# CITY OF ALBUQUERQUE

**Re: Orpheum Community Hub**  
**500 2<sup>nd</sup> Street SW**  
**Traffic Circulation Layout**  
Engineer's/Architect's Stamp **09-20-2018 (K14- D114)**

Based upon the information provided in your submittal received 09-26-2018, the above referenced plan cannot be approved for Building Permit until the following comments are addressed:

Traffic Circulation Layout

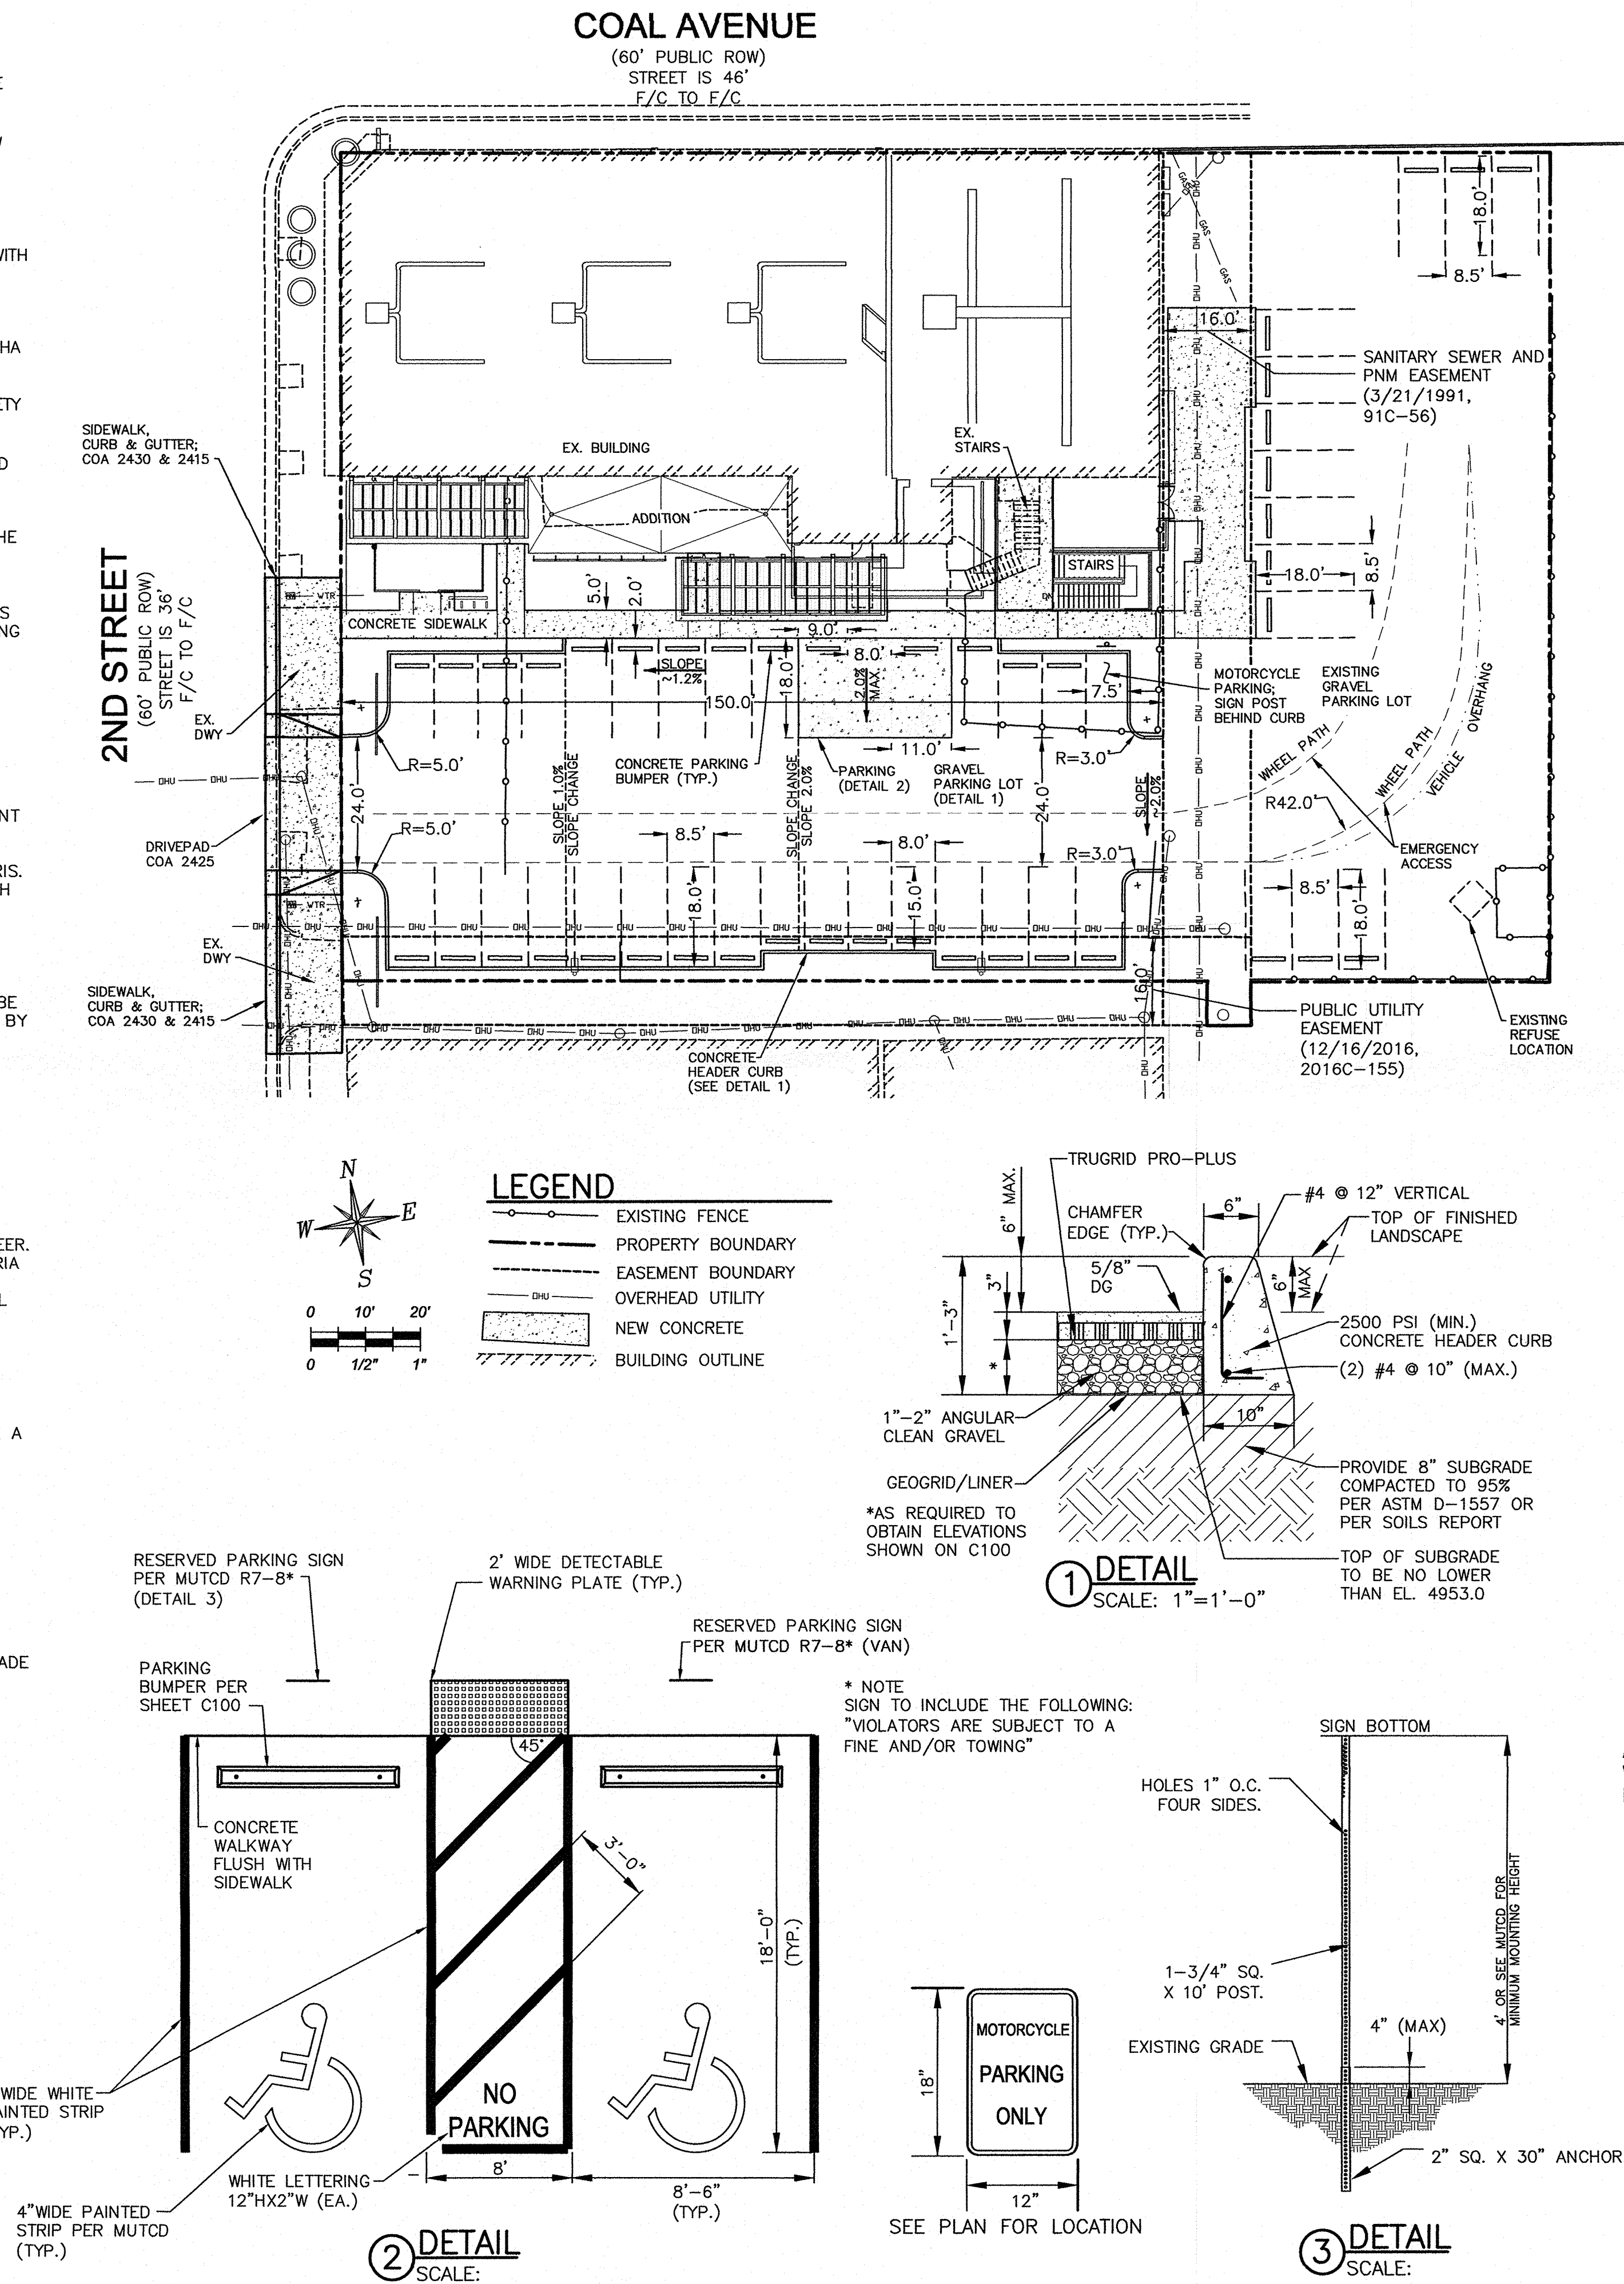
1. Please check the TCL checklist and ADA accessibility checklist that are attached.
2. List the number of parking spaces required by the zoning code as well as the proposed number of parking spaces including bicycle and motorcycle parking.
3. A scale of 1"=20' is recommended for sites less than 5 acres.
4. Driving surface should be capable of supporting at least 75,000 Lbs. Please verify that.
5. Unused curb cuts must be closed.
